**RE: Mister Car Wash 2502 Fiesta Park
4703 Alameda Blvd. NE
Grading Plan
Hydrology File: C17D002A26C**

Based upon the information provided in your submittal received 07/09/2024, the Grading plan is **not approved** for Building Permit. The following comments need to be addressed for the approval of the above referenced project.

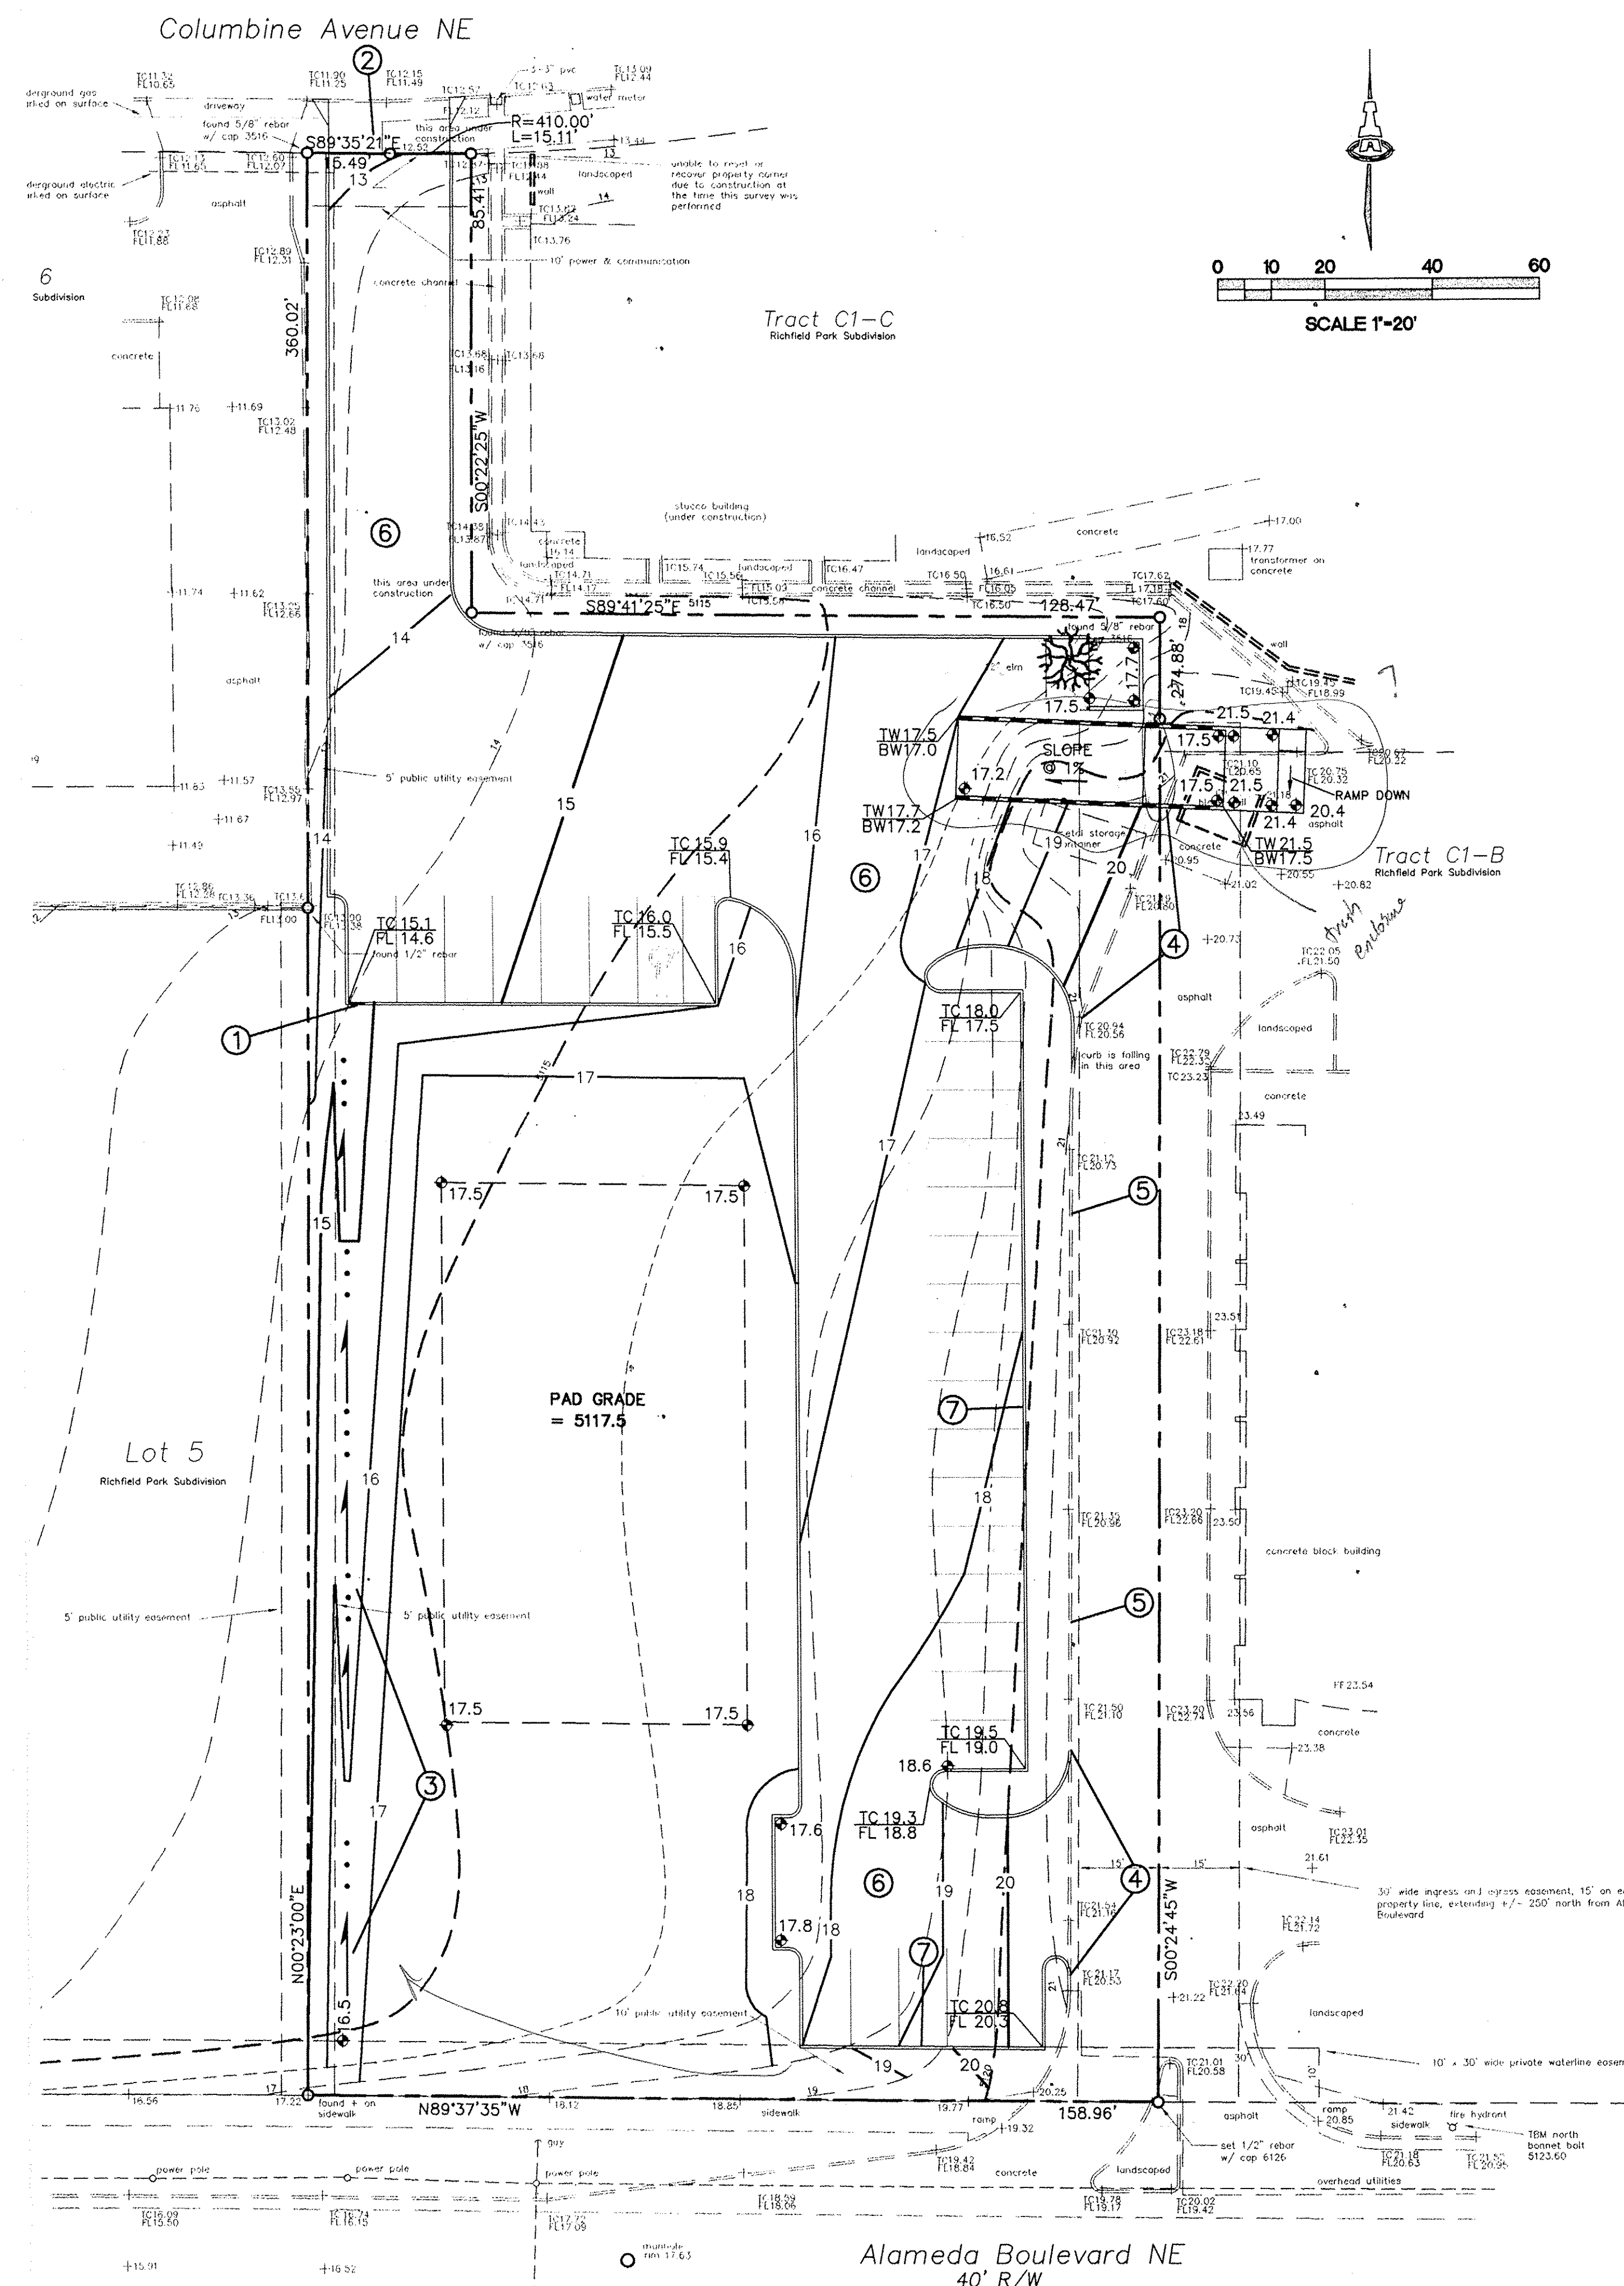
1. Per the DPM (http://documents.cabq.gov/planning/development-process-manual/DPM-2020-06-02_signed.pdf), the following must be on the Grading Plan. Please note the Grading Plan must be a stand-alone construction document.

- a. Please provide a licensed New Mexico civil engineer's stamp with a signature and date.
 - b. Please provide a Vicinity Map. Typically, this is the Zone Atlas. This can be downloaded in pdf format from the City of Albuquerque's website.

- c. Please provide the Benchmark information (location, description and elevation) for the survey contour information provided.
 - d. Please provide the FIRM Map and flood plain note with effective date.

- e. Please provide a legal Description of the property.
2. Please use the procedure for 40 acre and smaller basins as outlined in Development Process Manual (DPM) Article 6-2(a). Please provide both the existing conditions and proposed conditions for the 100 year-6 hour storm event.

3. Please follow the DPM Article 6-12 Stormwater Quality and Low-Impact Development for the sizing calculations. To calculate the required SWQV, multiply the impervious area (Square feet) draining to the BMP by (0.42 inches for new development sites) divided by 12 to get the required volume in cubic feet. The calculations of both the required and the provided volume of each BMP must be shown on the Grading and Drainage Plan. Each BMP should be labeled on the Grading and Drainage Plan with the required SWQV and associated water surface

elevation and the 100-year water surface elevation. Landscaping of surface BMPs is also required to be noted on the Grading and Drainage Plan.

4. A waterblock, per COA Paving Detail No. 2426, is required at the driveway entrance.
5. Show the storm drain system on the plan.
6. Show the pond detail with elevations.
7. All ponds (stormwater quality, detention, or retention) must have an emergency spillway. This can be a typical spillway, a standing pipe with an outlet pipe to either the curb or inlet, or a sidewalk culvert.
8. Please follow the DPM Part 6-14(C) Grading Plan Checklist and verify that the plan drawing size is 24x36 inches.
